Response to Request for Advice – 104-116 Regent Street, Redfern – Student Accommodation (SSD-12618001)

This letter has been written in response to the Request for Advice Letter dated 2 March 2022 from the City of Sydney (SSD-12618001).

Table 1 Response to Request for Advice

DRAWING SERIES
Elevations
DRAWING TITLE
Regent St - Elevation

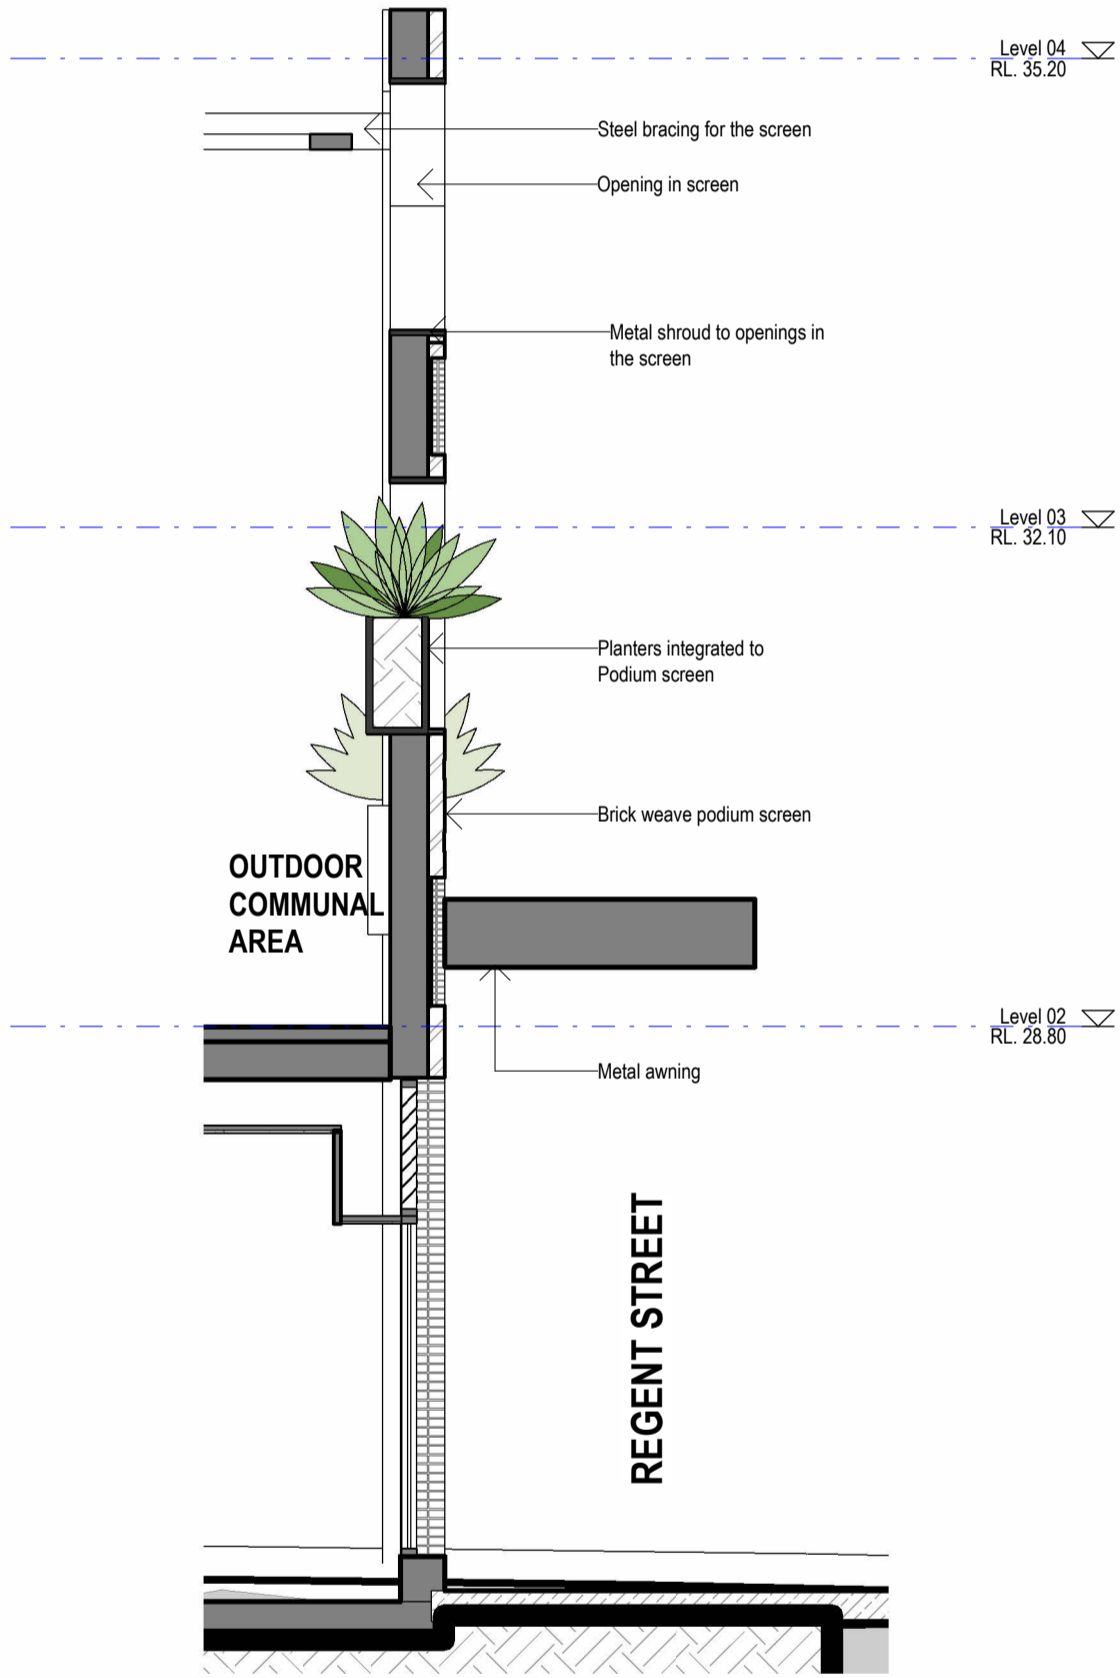
City of Sydney Matter	Design Amendments	Response
<p>“The Regent Street entry provides minimal passive surveillance as a result of the location of the bicycle parking facilities that occupy the majority of frontage. It presents areas of concealment with Crime Prevention Through Environmental Design (CPTED) concerns for both residents and the public.”</p>	<p>Adjacent to the entrance on Regent Street the façade has been redesigned to removal any areas of possible concealment or entrapment.</p> <p>Bicycle parking has been split and additional area is being utilized as office space facing the street to improved street activation.</p>	<p>The bicycle parking does not represent a majority (more than 50%) of the street frontage and has been split and reconfigured, it constitutes less than 10 metres of the regent Street Frontage which is less than the perceived “majority”, see Figure 3.</p> <p>The Regent Street entry provides direct passive surveillance and sight lines into and out of the building onto Regent Street as outlined within Figure 4. The areas within the building are highly activated with the addition open plan games room and will maintain and increase passive surveillance. As an entry space this area will be used by residents greatly activating this space.</p> <p>The entry area and bicycle parking area will be well lit, includes a skylight, uses clear materials, and will include CCTV at the detailed design stages this will allow the Entry Space to be free for opportunities for concealment for members of the public utilising Regent Street.</p> <p>The Regent Street entry provides natural surveillance and direct sight lines into and out of the building into Regent Street in accordance with the CPTED Principles for Natural Surveillance.</p>

FIGURE 17 - LEVEL 1 - ACTIVATION

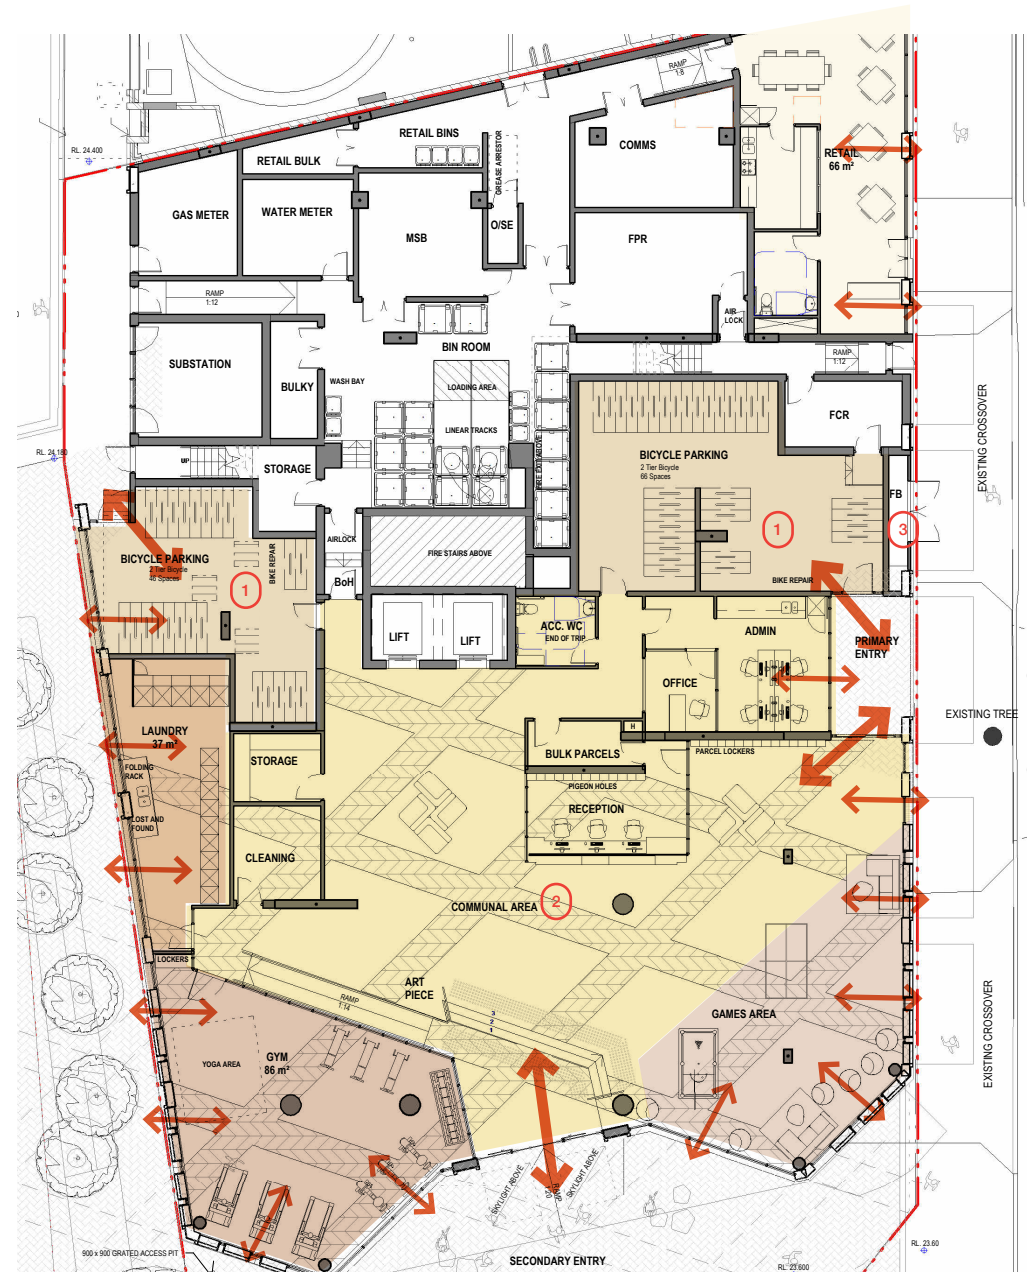
City of Sydney Matter	Design Amendments	Response
<p><i>e. Active Frontages</i></p> <p><i>The proposed development has frontages to Regent and Margaret Streets as well as the future through site link and provides opportunities for street activation. However, the development does not provide a genuine active frontage with good levels of passive surveillance.</i></p>	<p>Figure 1 and Figure 2 are used to make a comparison to show how the ground level floor plan has been redesigned to address the City of Sydney’s comments.</p> <p>The usage of the area on the corner of Regent Street and Margaret Street has been changed from study rooms to an open plan games area that will greatly increase usage of the space providing further active frontage to the street and increased passive surveillance.</p> <p>Adjacent to the entrance on Regent Street the façade has been redesigned to removal any areas of possible concealment or entrapment.</p> <p>Bicycle parking has been split and additional area is being utilized as office space facing the street to improved street activation.</p>	<p>WSP do not agree with this sentiment from Council. According to the Sydney Development Control Plan 2012:</p> <p>Active Frontage means street frontages where there is an active visual engagement between those in the street and those on the ground floors of buildings. Frequent building entries that face and open towards the street, transparent street frontages, quality materials and refined details, and mixed land uses will make streets more diverse and attractive for pedestrians and increase the perception of safety and encourage higher levels of pedestrian activity.</p> <p>There is a total of 115.44m of building and street frontage, of which vast majority of is activated through retail space (mixed land uses), glass, natural surveillance and building entries.</p> <p>This allows for the ground floor of the development to provide active visual engagement between street pedestrians and those within the building. The proposal provides building entries along Regent Street and Margaret Street activating these frontages with high pedestrian activity. Where appropriate transparent street frontages have been provided with high quality materials and details provided, this allows the pedestrians and occupants to see in and out of the building providing a high level of activation.</p> <p>A retail/café space has been provided along the Regent Street greatly activating the streetscape for pedestrians and their safety and greatly reducing any CPTED issues. Further lighting and well-placed CCTV, and clear be considered at the detailed design stages mitigating any safety concerns.</p> <p>It is therefore considered that that proposal is provides a genuine active frontage with good levels of passive surveillance. See Figure 2 which illustrates the amount of activated frontage provided by the proposal.</p>

FIGURE 20 - LEVEL 01 - MARGARET STREET ENTRANCE - SKYLIGHT LOCATION

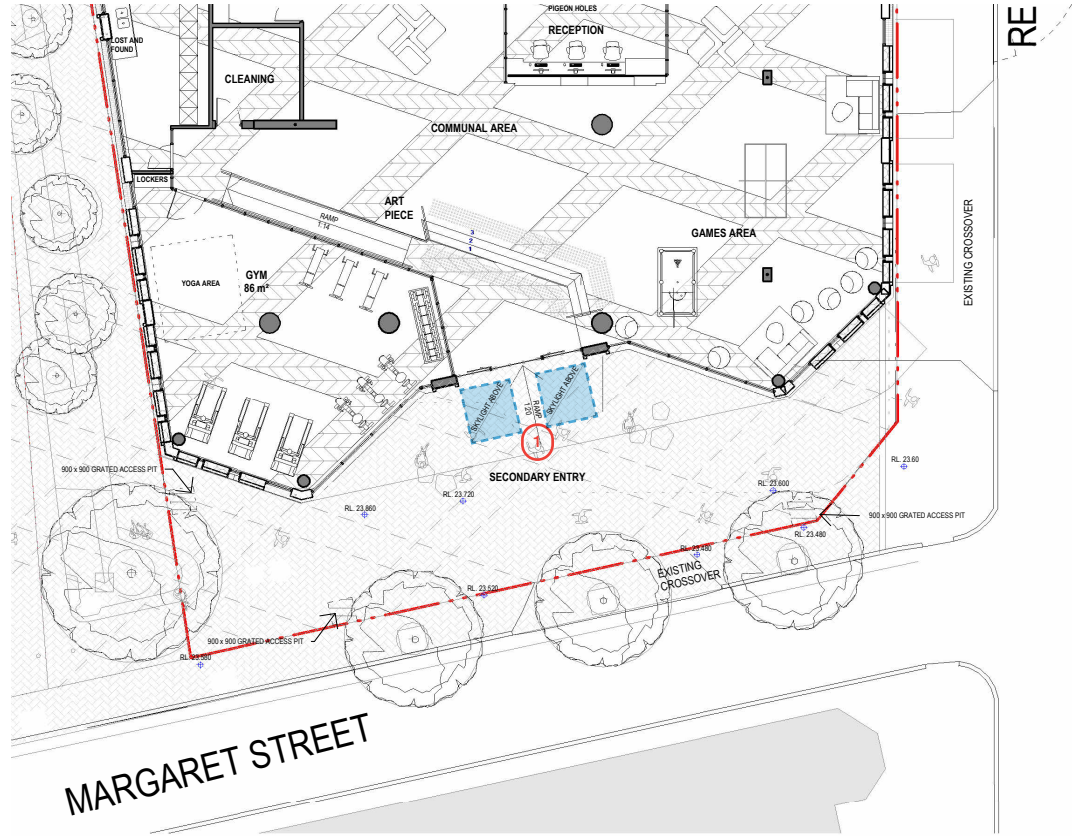
City of Sydney Matter	Design Amendments	Response
<p>The Margaret Street facade includes a recessed secondary entry, which sits in an under croft of the podium. This fails to positively reinforce the street edge, would receive no natural light due to its orientation, and creates CPTED concerns for both residents and the public.”</p>	<p>The skylights proposed in the slab above the entry will provided an increased amount of natural light and give the feeling of perceived surveillance to anyone on the street in front of the entrance.</p>	<p>The Margaret Street Entry has been designed to be short and obtuse in recess. The Entry provides a positive street edge element which would result in street activation and the maximising of passive surveillance into and out of the building onto Margaret Street as indicated in Figure 5.</p> <p>The entire façade has been designed with a ‘permeable edge’, which will increase the sense of being seen from within the building and seeing out of the building. This allows for the upper levels of the podium to see out of the building onto Margaret Street.</p> <p>The Entry way includes external widows that are transparent in material which provide adequate passive surveillance into Margaret Street.</p> <p>Overall, the Margaret Street Entry provides a great level of street activation as an entry point with a high level of passive surveillance in accordance with the Principles of CPTED.</p> <p>The entry way will include suitable lighting and CCTV at the detailed design stage to minimise any potential CPTED issues or concerns for residents and members of the public.</p> <p>Overall, the proposal has sought to minimise any CPTED concerns at this stage.</p>
